Deadline 6 submission

On behalf of The British Horse Society (both Bedfordshire and Cambridgeshire) and the Borough of Bedford Local Access Forum.

East Park Energy
Figure 5-16b: Viewpoint 12 (Existing Winter View)

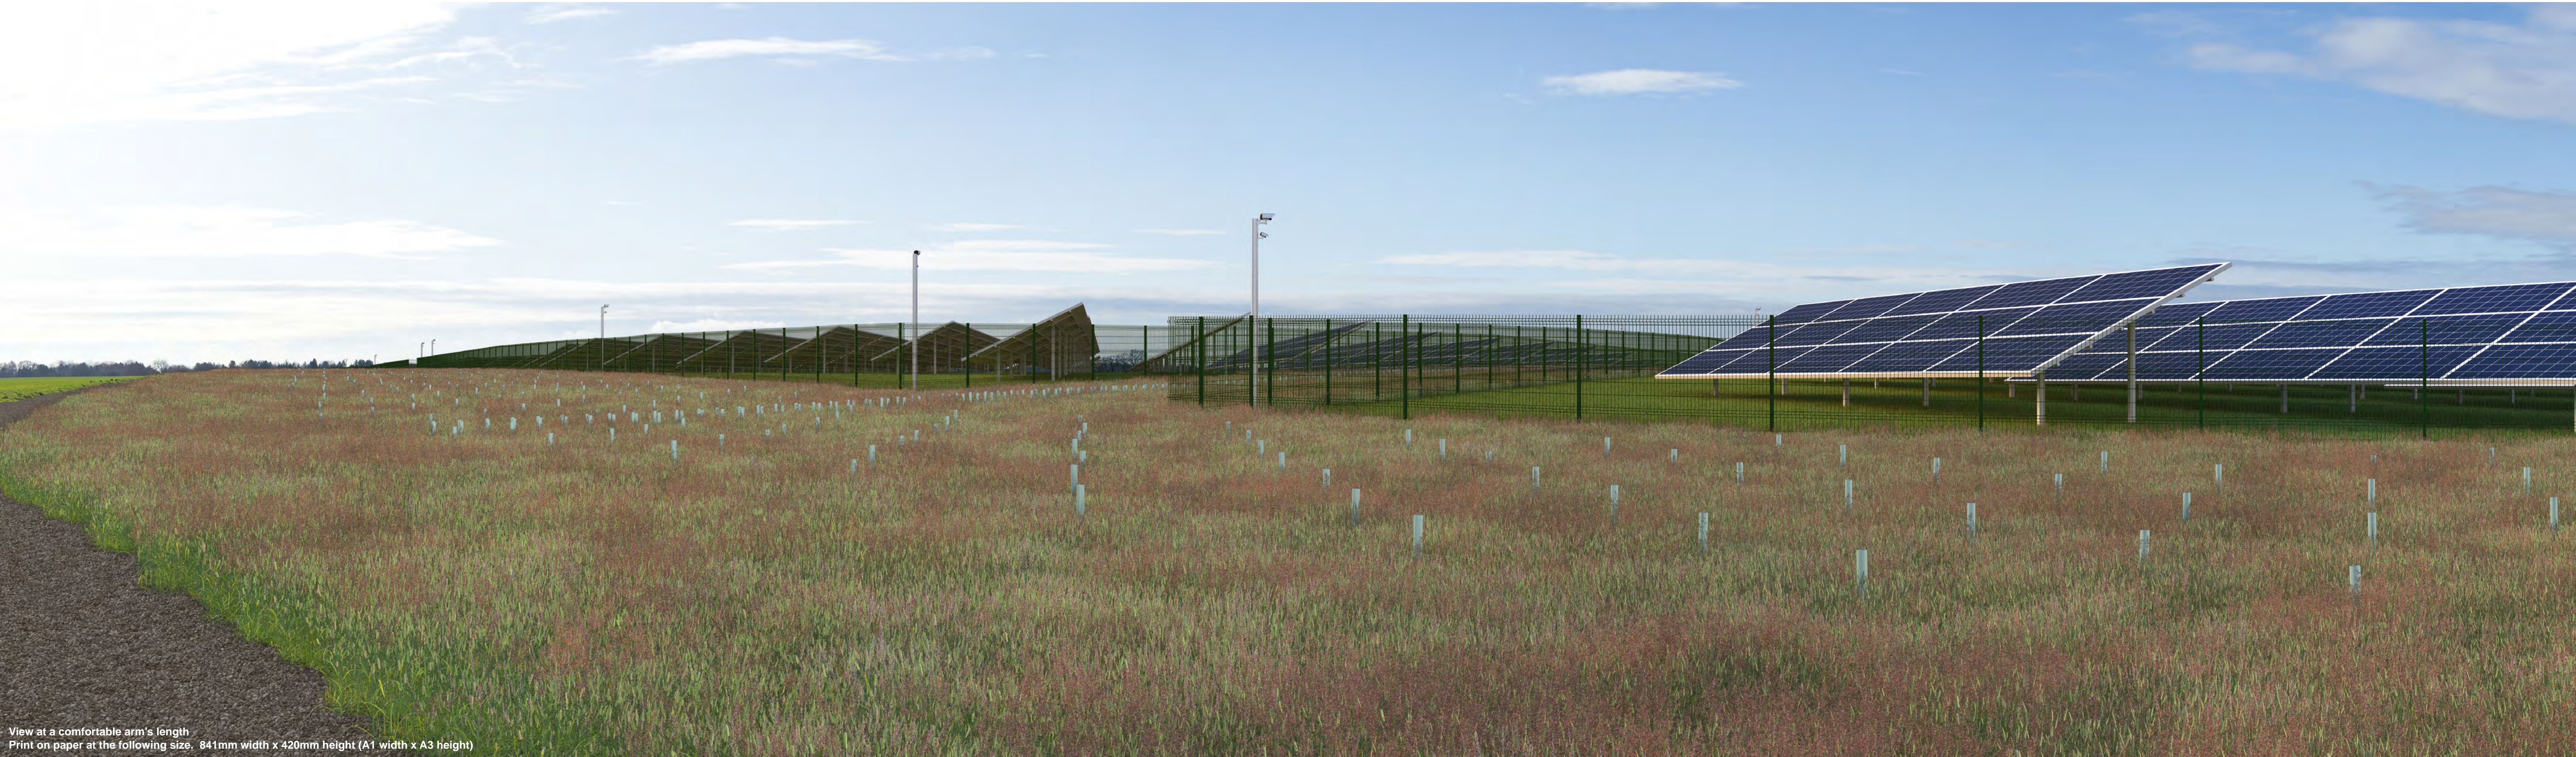
I note that point 4 of Appendix A of Applicant's REP4-110 is shaded grey. It states that the LAF was to submit ‘plans’ relating to viewpoint 12 – I believe this should be photos. I assume that the grey indicates that it has not been done? These photographs form the final two pages of our post-ISH submission (REP4-044) and were emailed to the Applicant on 10 June.
